SCOTTISH POWER – EAST ANGLIA ONE NORTH AND EAST ANGLIA TWO

Cable Corridor Flood Risk during Construction at Work Plan Nos. 19 and 20¹

[\[REP11-004\]](#) crossing the Hundred River valley and at residences in Gypsy Lane, Aldringham

Original study area did not extend west of Aldeburgh Road to avoid interaction with woodland and residential titles

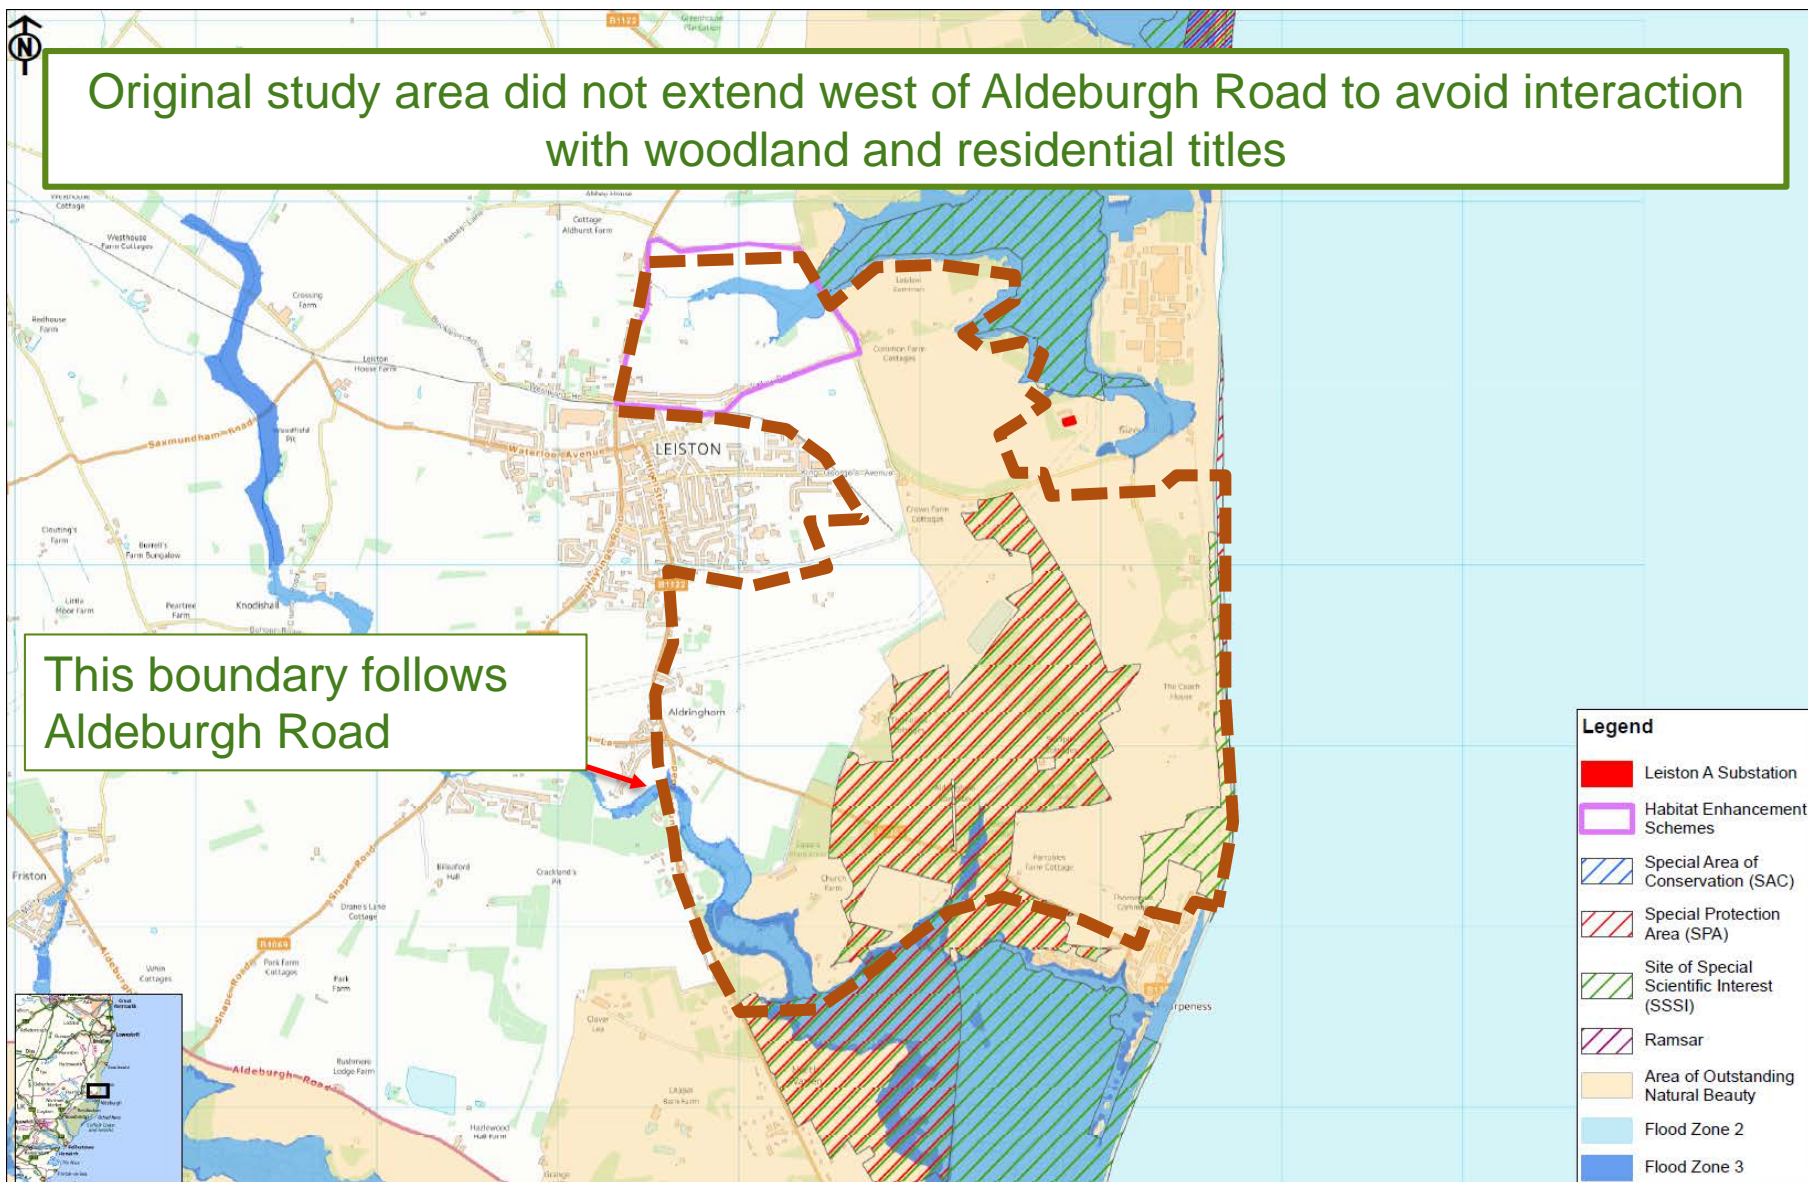
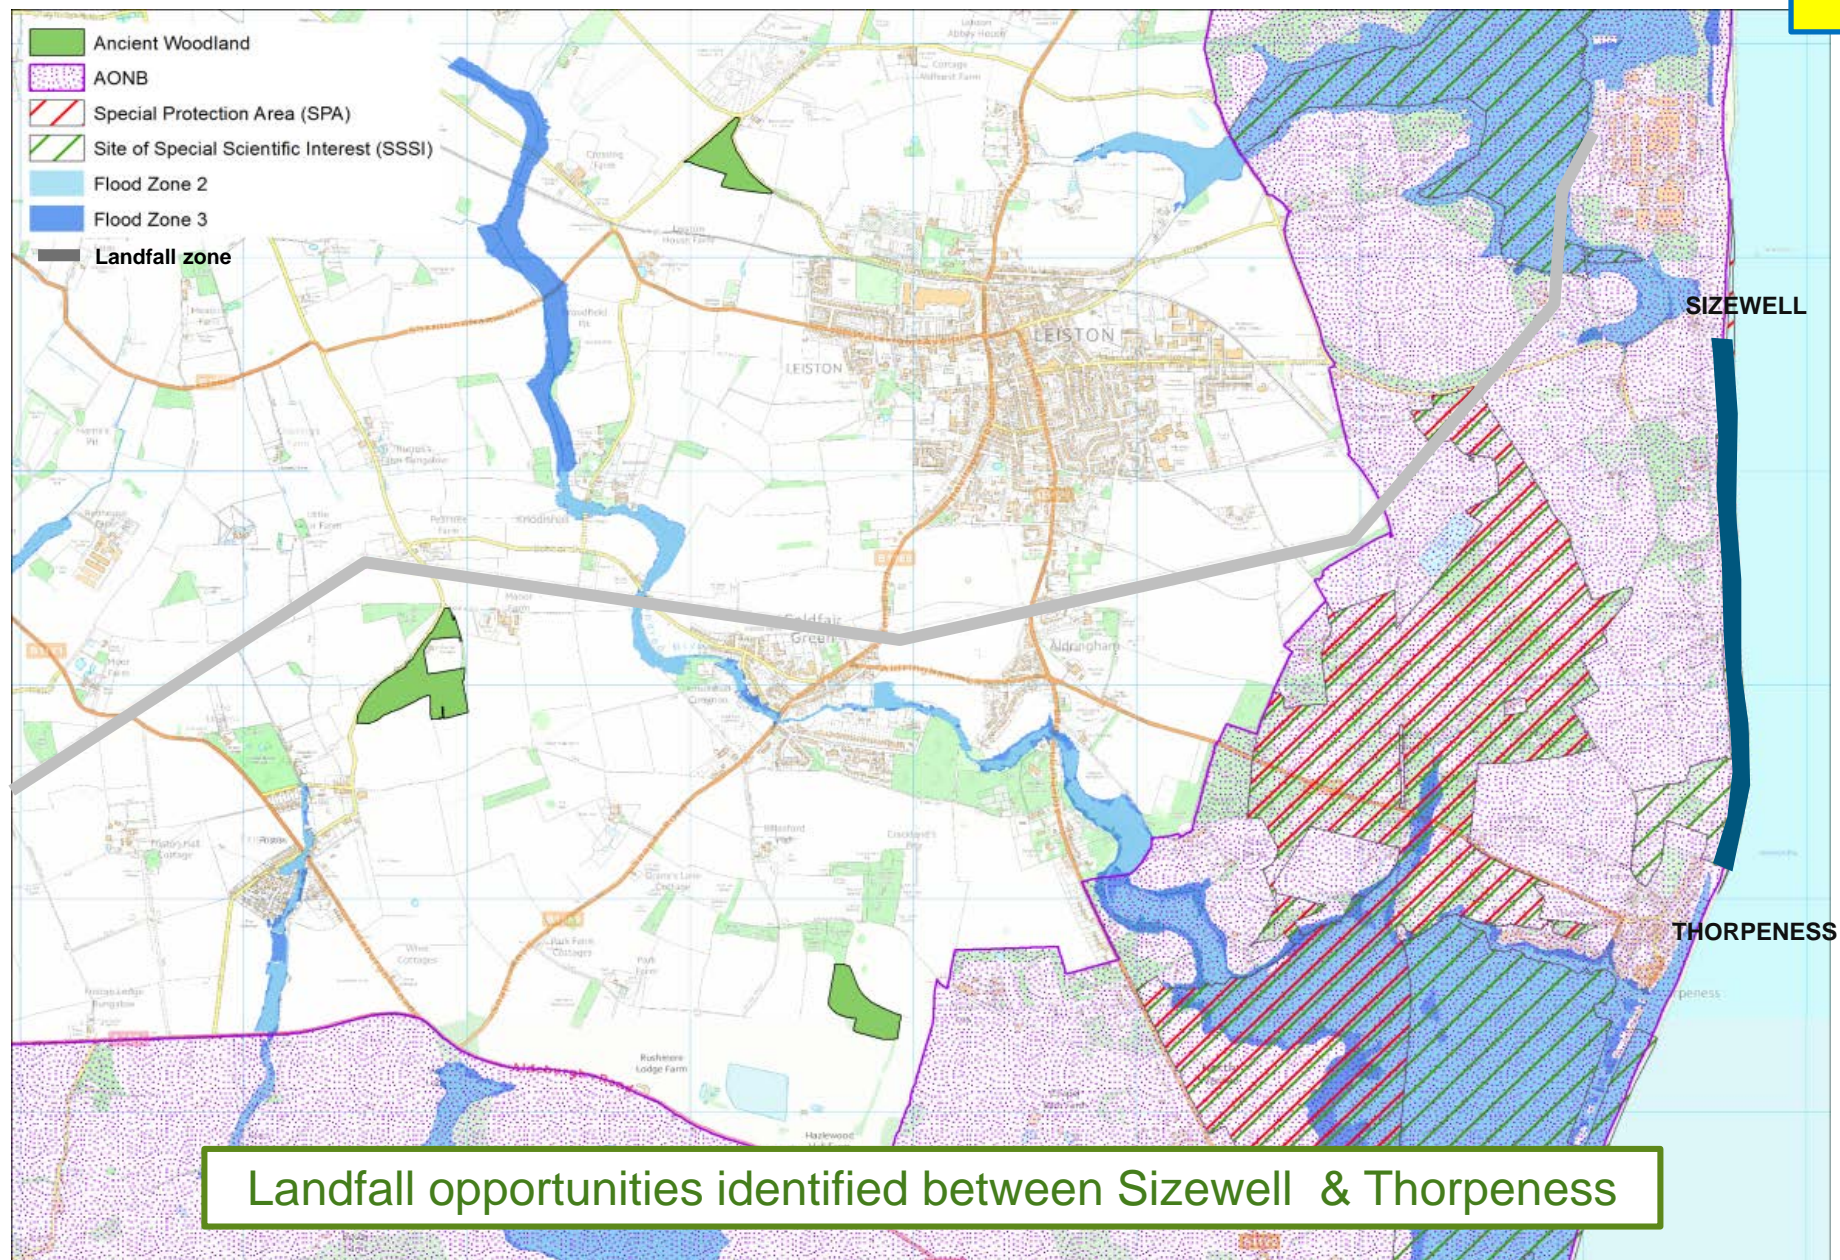
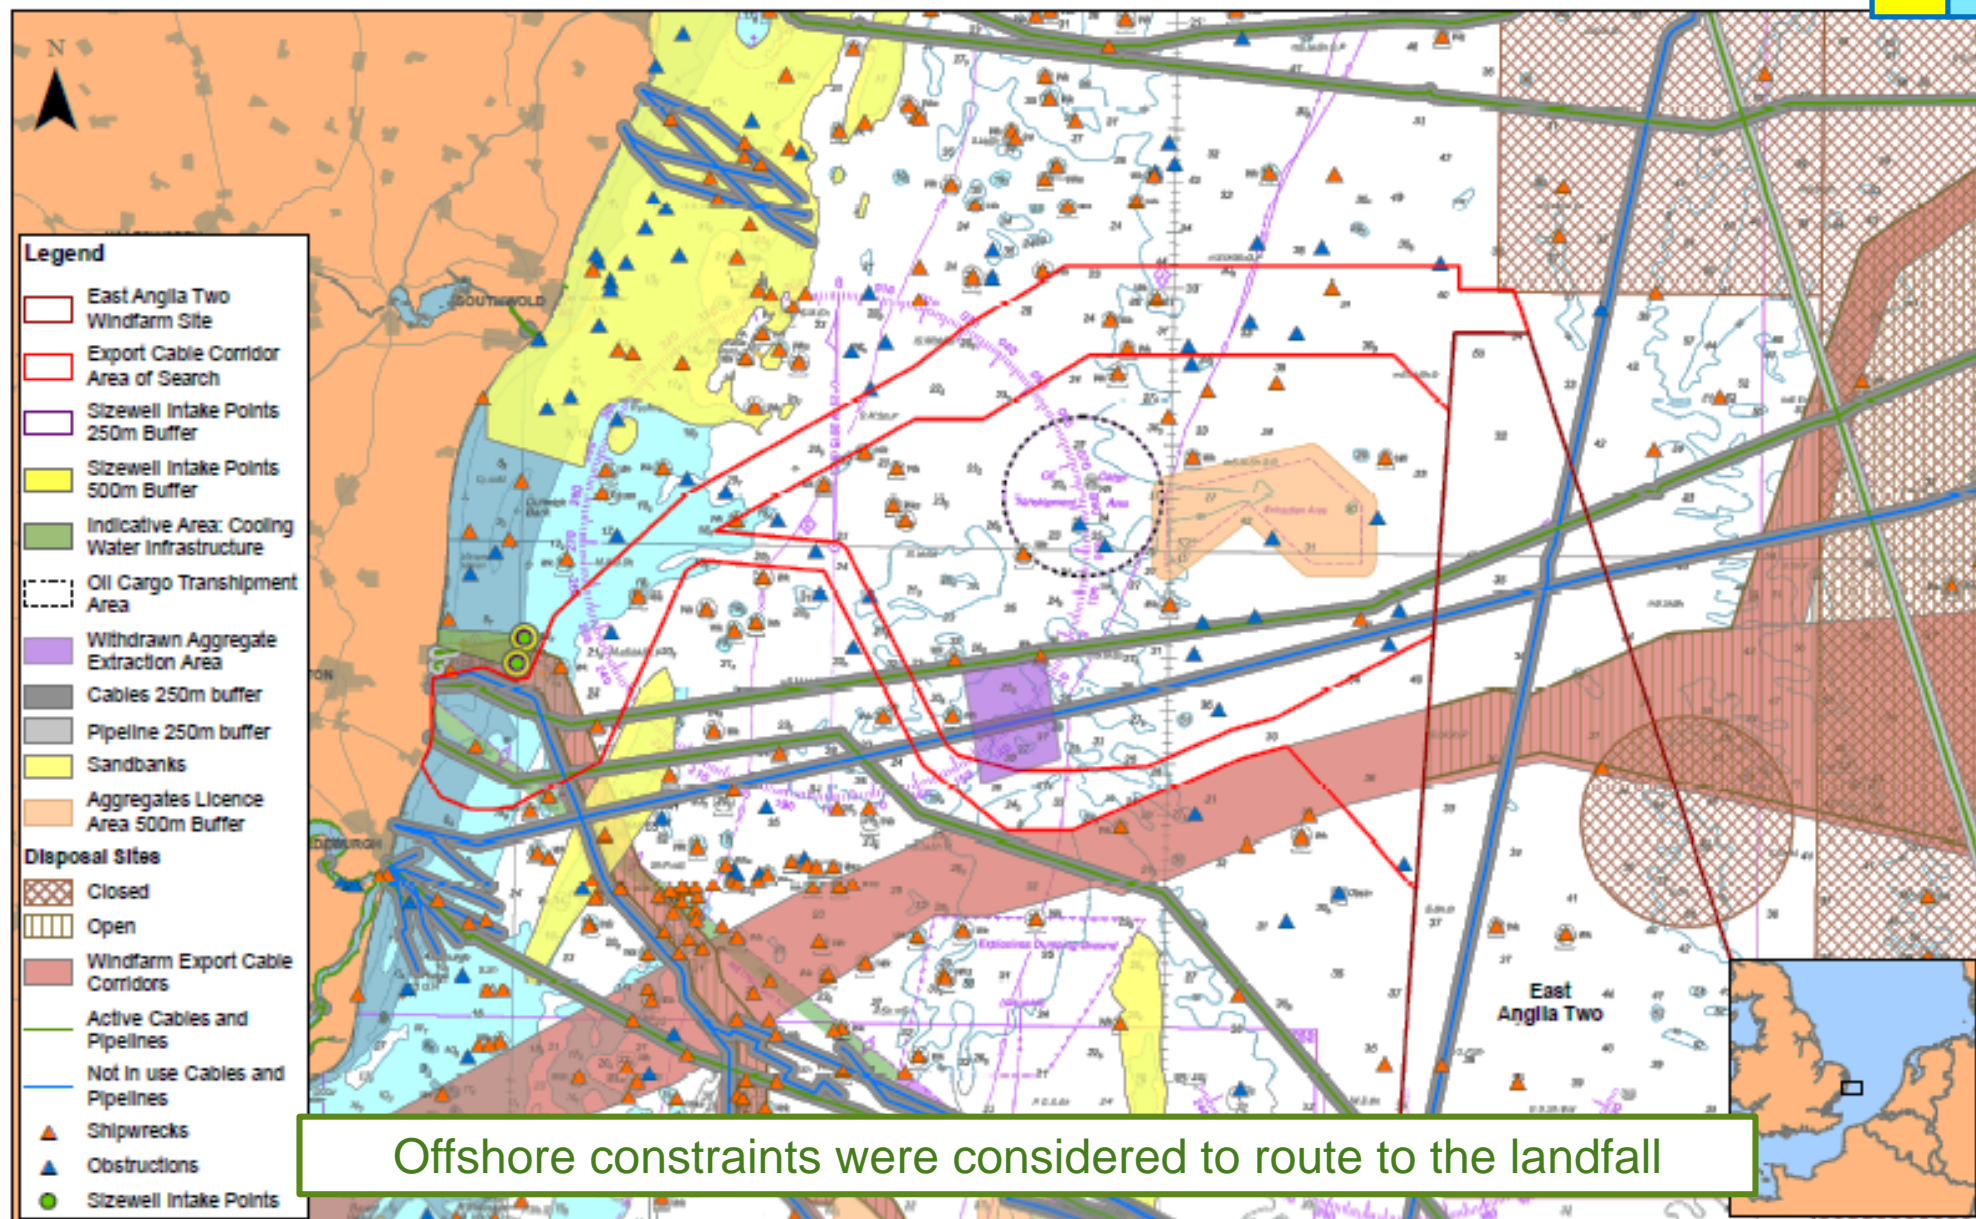
- 06 When selecting a substations site, the Applicants decided upon a route from landfall to Friston that would cross the Hundred River and pass through the North-South midpoint of Aldringham village. Two cable corridors with up to 70 metres combined width would cross the Aldringham Hundred River and its floodplain at Work no 19.

- 07 No alternative routes to Friston were evaluated and no expert assessment has been made of additional impact of cable corridor construction works over and above the present fluvial and pluvial flood risk across the Hundred River and its flood plain.
